CITY OF ALBUQUERQUE

March 1, 2013

**Re: DaVinci's Restaurant, 2904 Indian School Rd. NE,
Traffic Circulation Layout
Architect's Stamp dated 02-14-13 (J16-D005)**

TCL PLAN

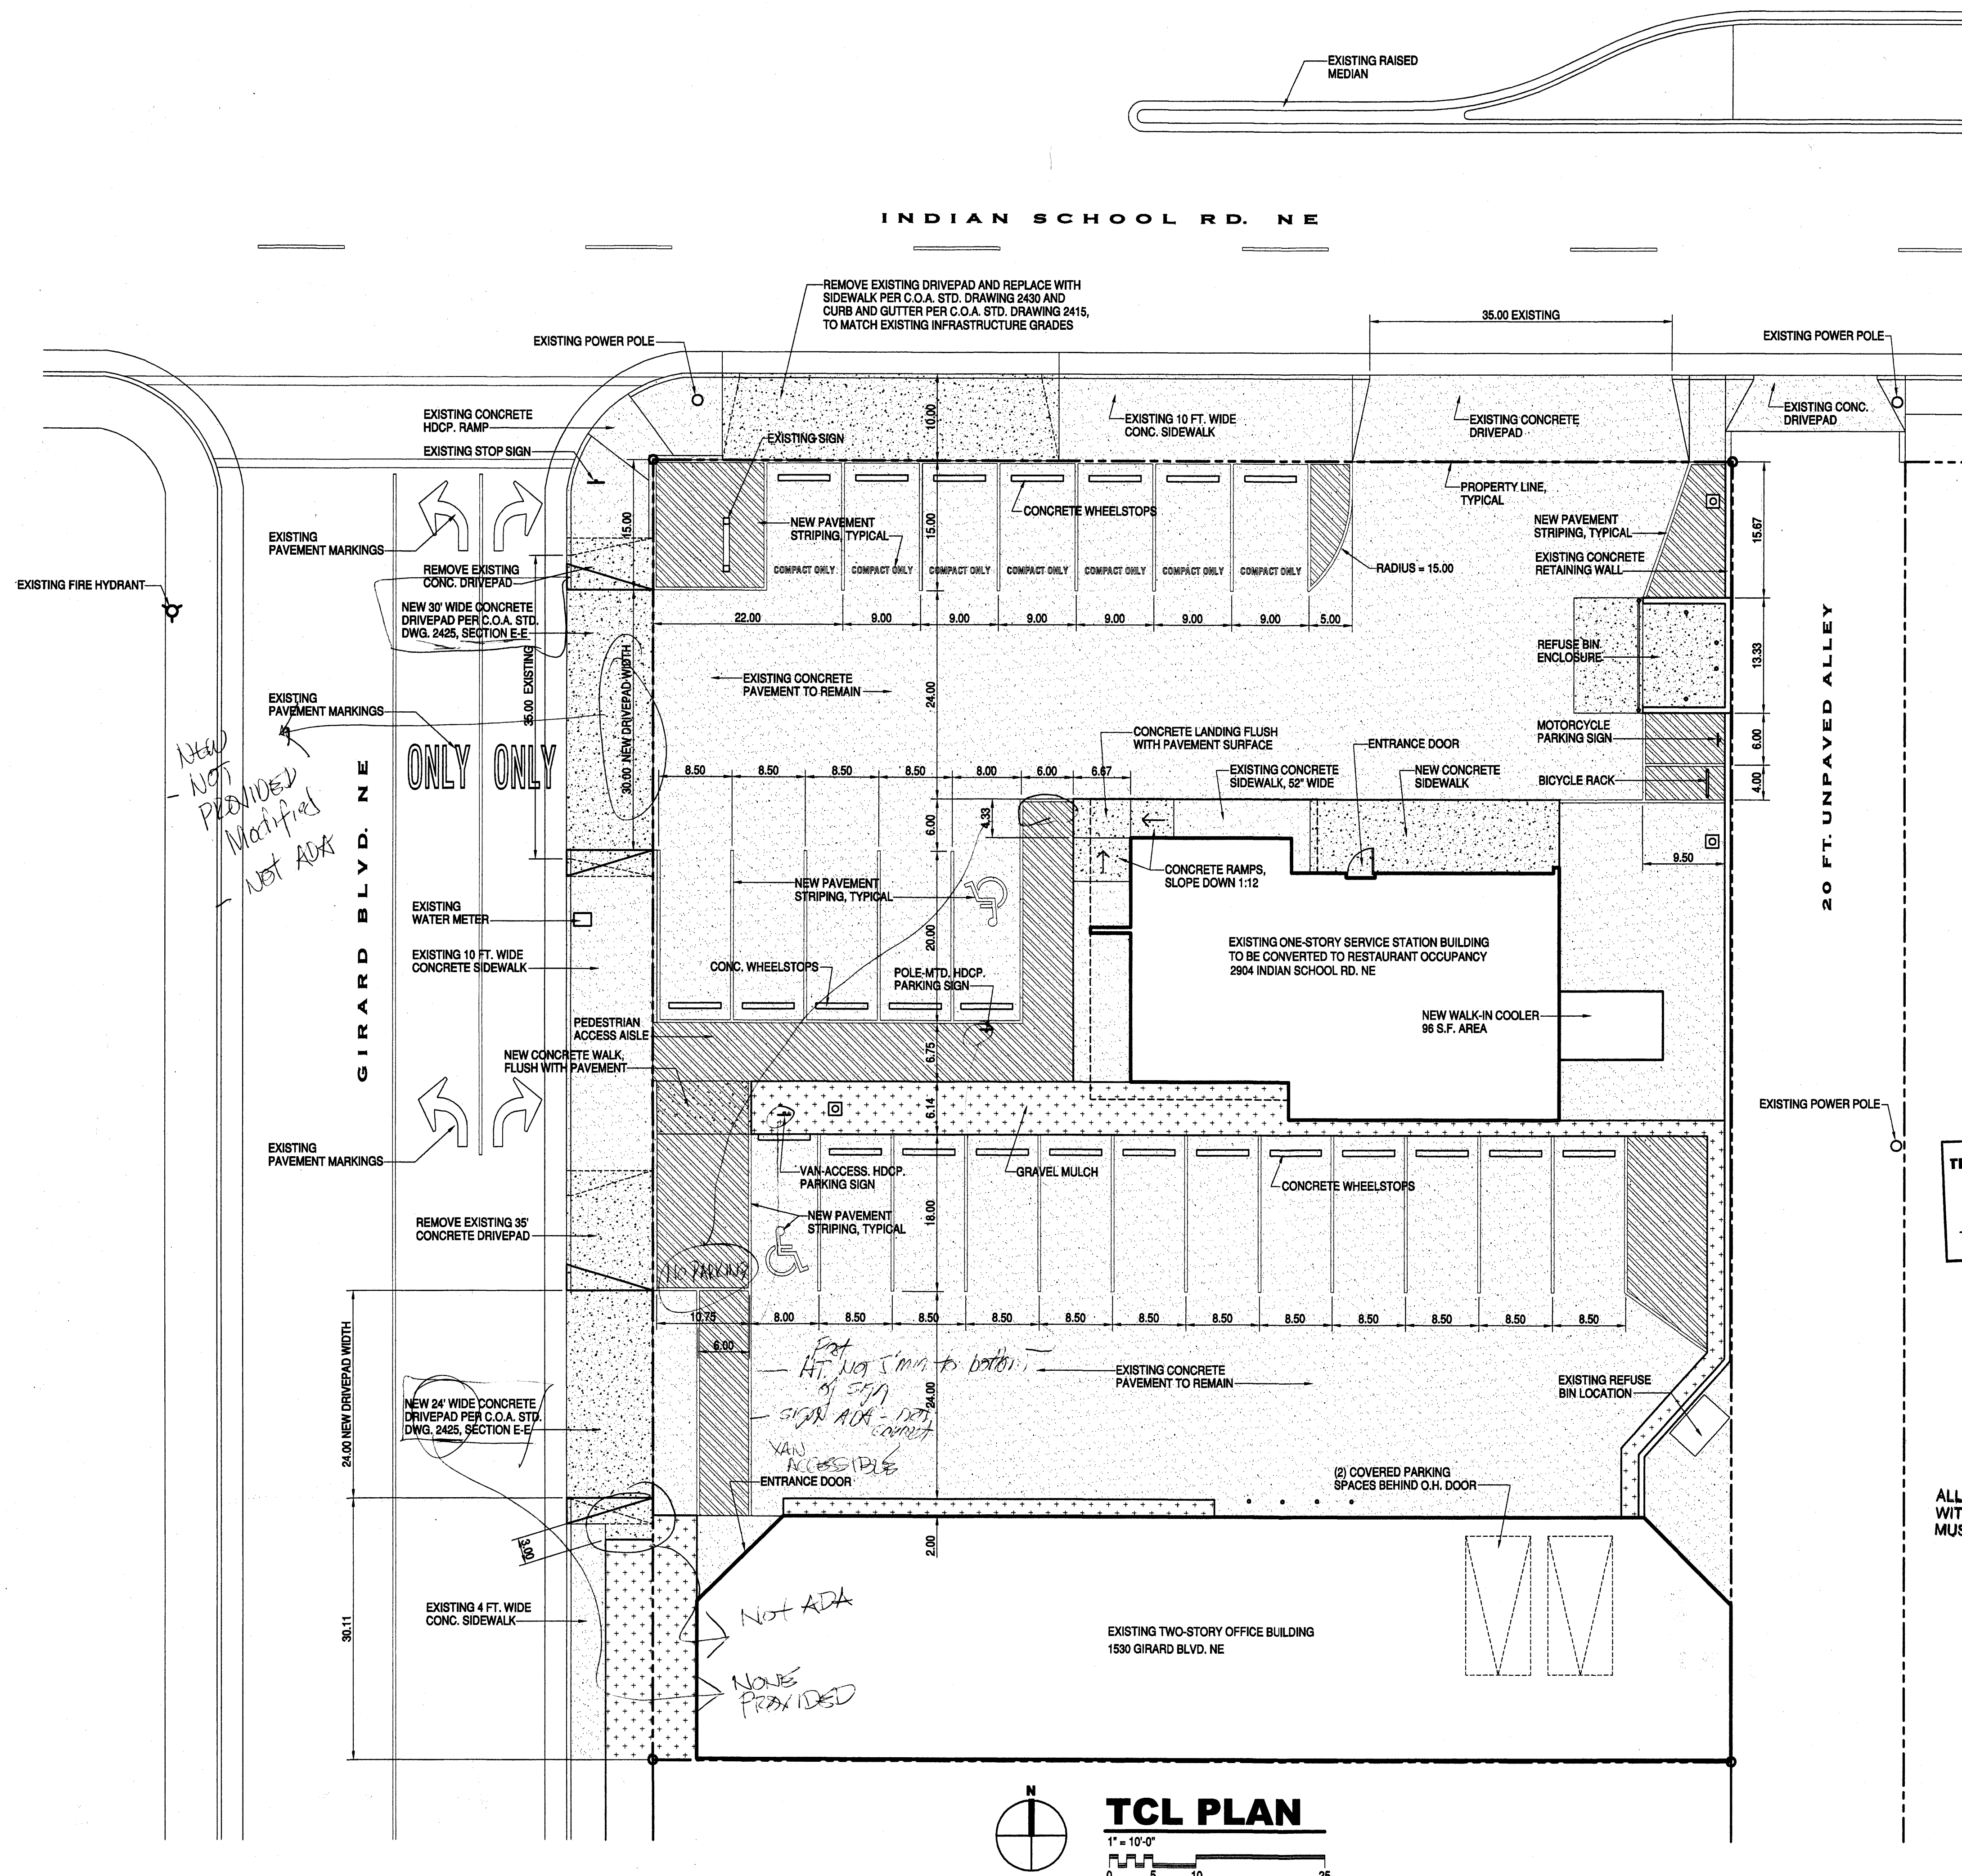
1. Abandoned or unused driveways must be removed and replaced with sidewalk per COA Standard Drawing #2430 and curb and gutter per COA Std. Dwg. #2415, to match existing infrastructure grades.

2. The proposed "pedestrian access aisle" can not be located behind parked vehicles. Please modify.
3. Clearly show the 6-foot wide, ADA accessible pedestrian pathways from the public sidewalk to the entrance of the restaurant and the office building and from the ADA parking stalls to the buildings. These paths cannot cross behind parked vehicles. If it is necessary for the pathway to cross the vehicular way, it should be at a 90 degree angle.

4. Because both buildings share the parking lot areas, please provide a 6 foot ADA accessible pedestrian pathway between buildings within the site to provide connectivity. Be sure the path does not cross behind parked vehicles.

5. A five-foot keyway is required for deadend parking aisles.
6. Please list the width and length for all parking spaces, including ADA stalls and associated HC access aisles.

7. Please list the width of the parking lot access aisle adjacent to the office building. A minimum of 24 feet is required for two-way vehicular movement.

8. Please include two copies of the traffic circulation layout at the next submittal.
9. Define width of the existing sidewalk along property frontages.

10. List the widths of all existing driveways.
11. Per the *Development Process Manual*, Chapter 27, Section 1, "Standard sheets must be 24" by 36" having a margin of 2" along the left and 1" on the top and bottom."

12. Please demonstrate that the existing sign does not interfere with the sight distance of the intersection. Please provide a sight distance exhibit (see the *Development Process Manual*, Chapter 23, Part B, Section 5.a).

13. The existing driveways off of Girard Boulevard currently guide traffic into the on-site parking and existing corner sign. The driveways must be modified to provide adequate vehicular access.

14. Please provide the landscape site plan with future TCL submittal. Please note that a curb is required between landscaping and all interfacing parking surfaces and sidewalks.

15. There appears to be areas where new striping is applied but not identified. Please clarify by labeling and dimensioning limits.
16. The site plan provides 24 parking spaces but the required parking is 25 spaces. Please correct.

17. Provide details for the "new curb ramp" adjacent to the ADA parking access aisle.
18. Please refer to all applicable city standards.
19. Since Girard Blvd. and Indian School are classified as arterial roadways, driveways with right in / right out only have a minimum driveway width of 30 feet (see the *Development Process Manual*, Chapter 23, Section 6, Part B.8). If the site has left turn access, the driveway has a 36-foot minimum width.

20. Please ensure all ramps are ADA compliant.
